RE: 8500 Glendale Ave NE
Grading and Drainage Plan
Engineer's Stamp Date: 11/10/18
Hydrology File: B20D067

Now onto the on November 13, 2018 submittal for Building Permit, based upon the information provided this Grading Plan **is not** approved for Building Permit. The following comments need to be addressed for approval of the above referenced project:

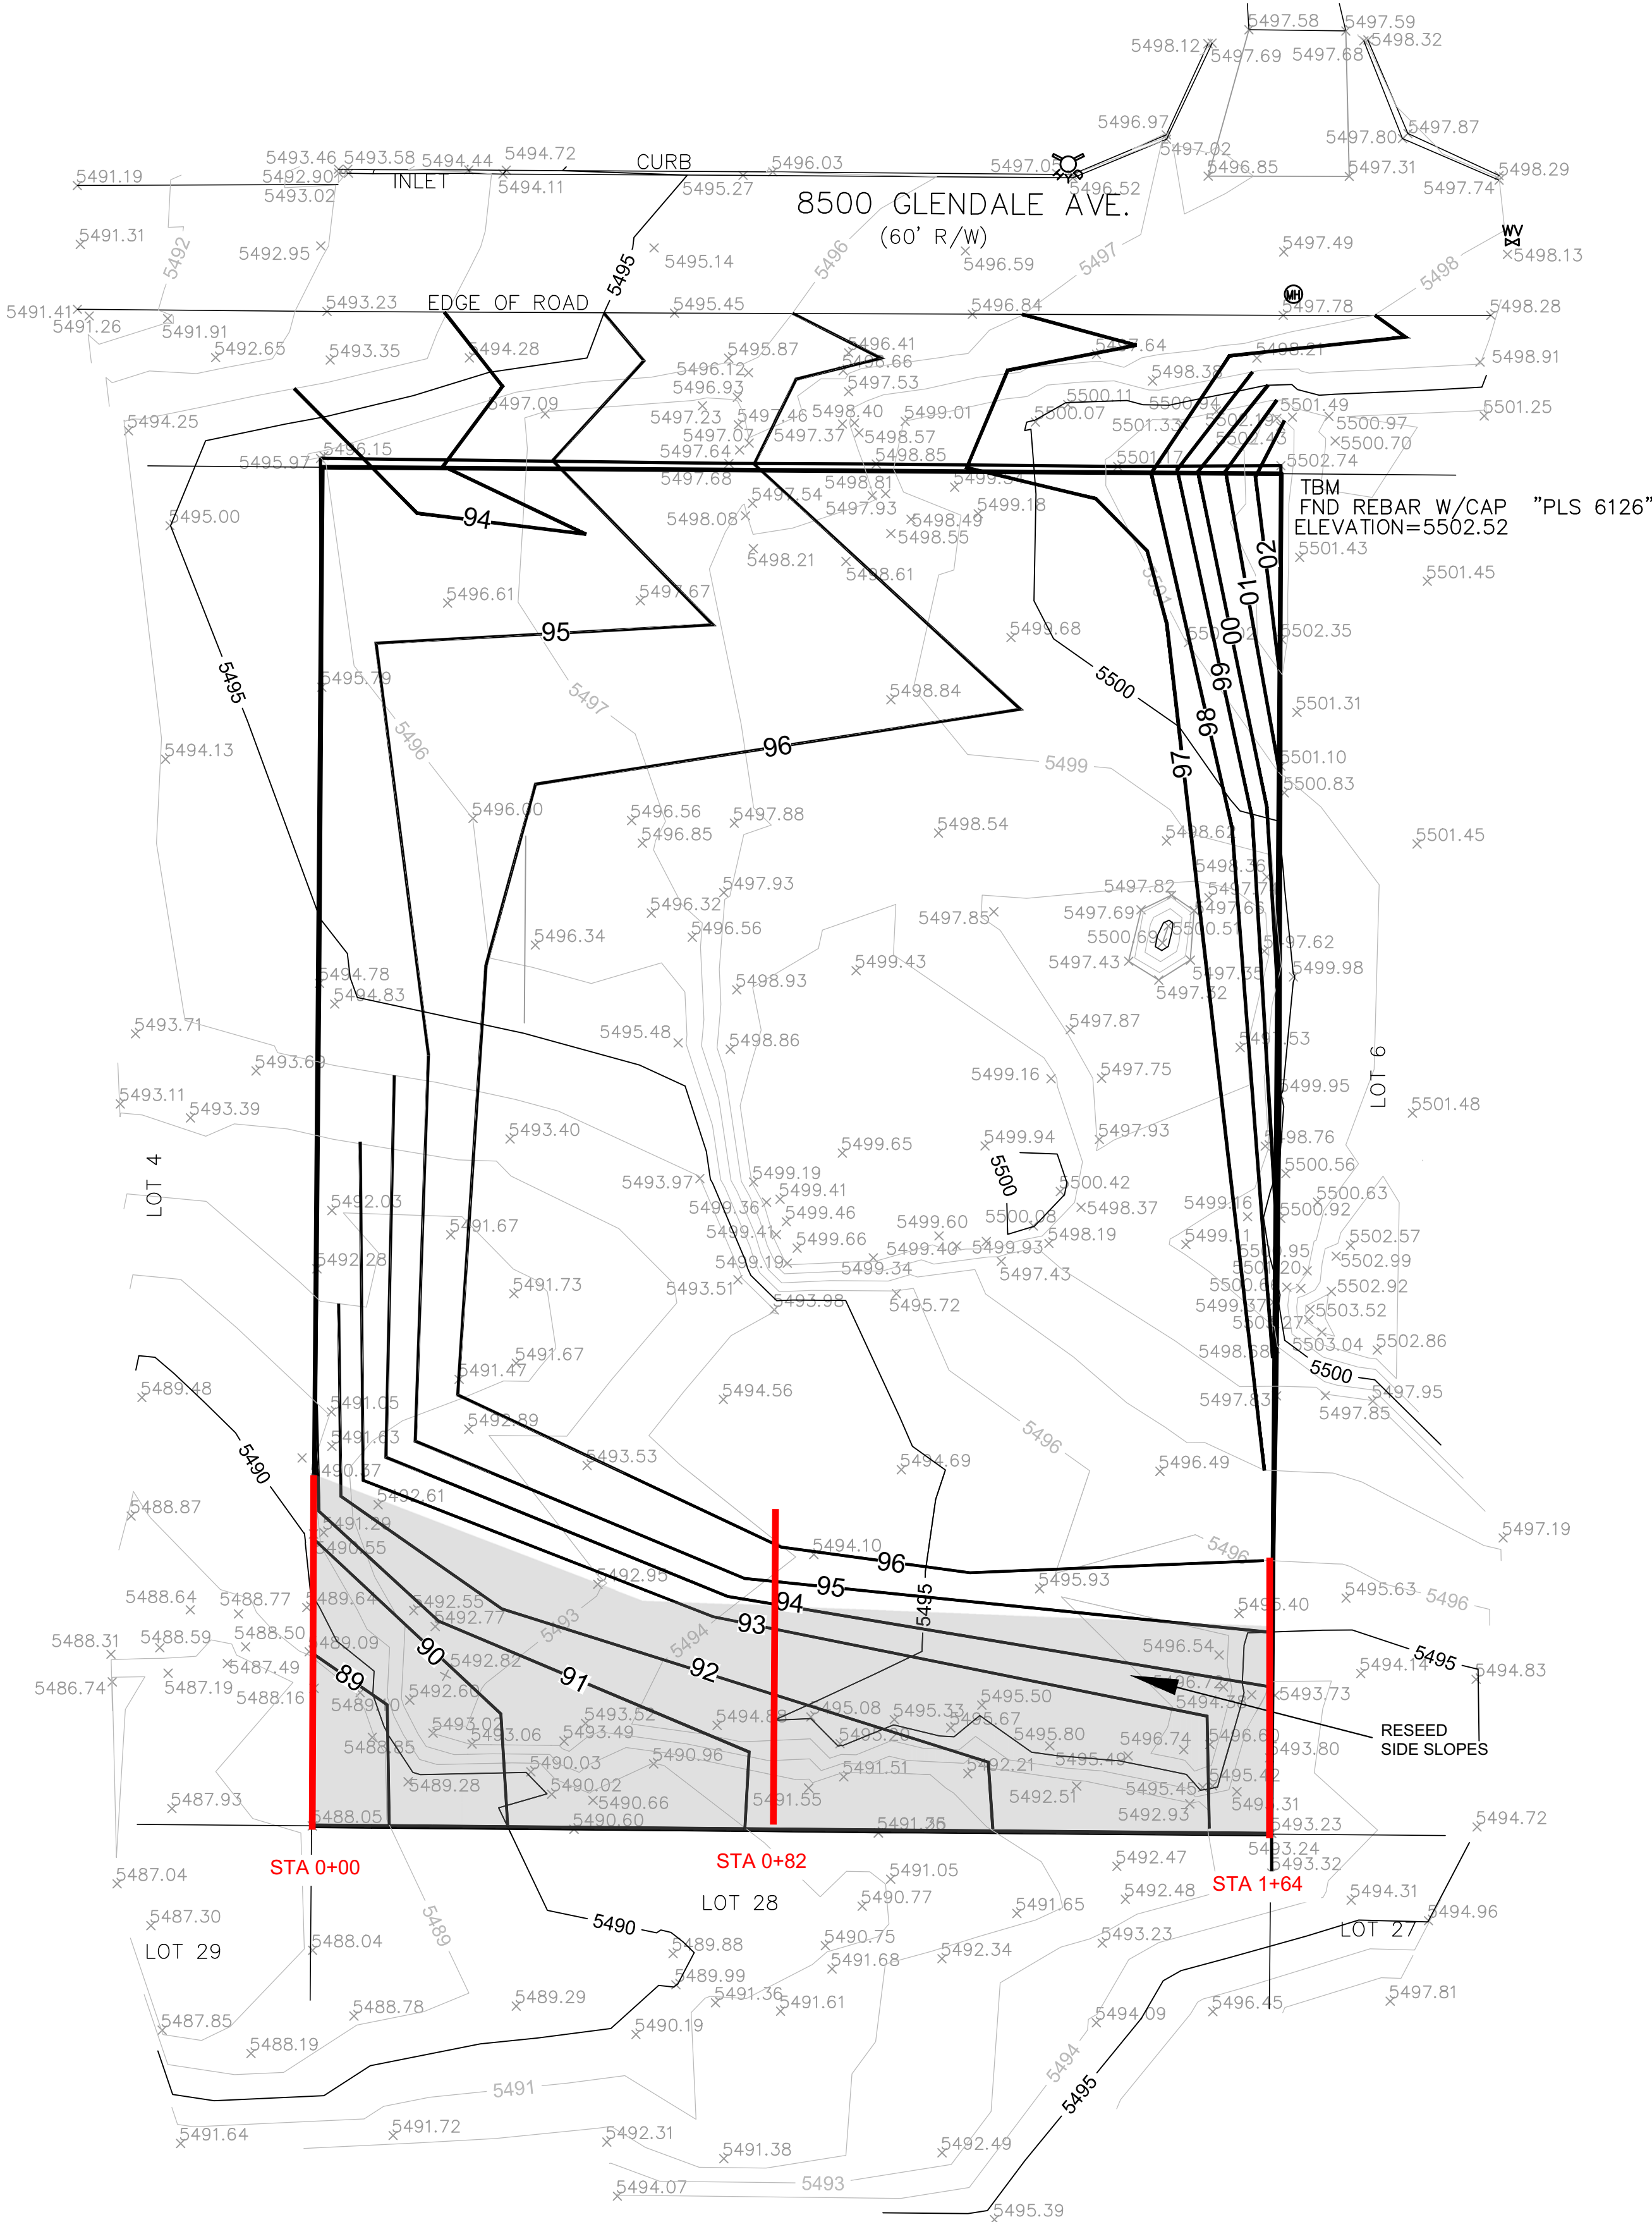
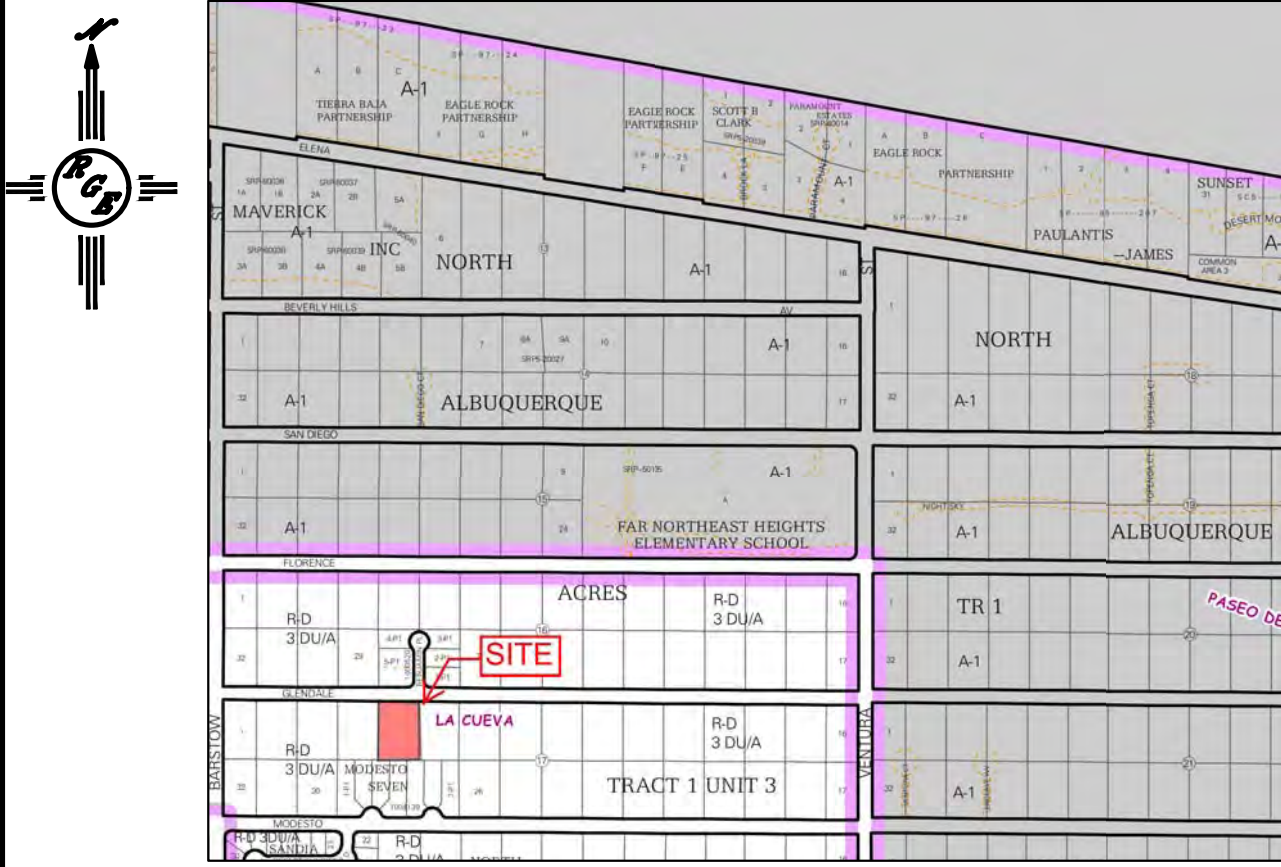
3. Please clarify the finished floor elevation and finished pad elevation. They are currently over the existing grade text and it is difficult to read.

4. Please provide the sections and structural calculations of the scour walls.
5. Please clarify the placement of the leader for the turn 4 blocks @ 5493.00 near the southwest corner of the property. It is currently pointing in the arroyo and not the scour wall.

6. Please provide an additional scour depth equation (3.90 in the Sediment and Erosion Design Guide) for flows at a 90° to the scour wall. The current scour depth equation is only good for flows parallel to the scour wall. This will increase the scour wall depth in the areas where flows are at 90° to it.
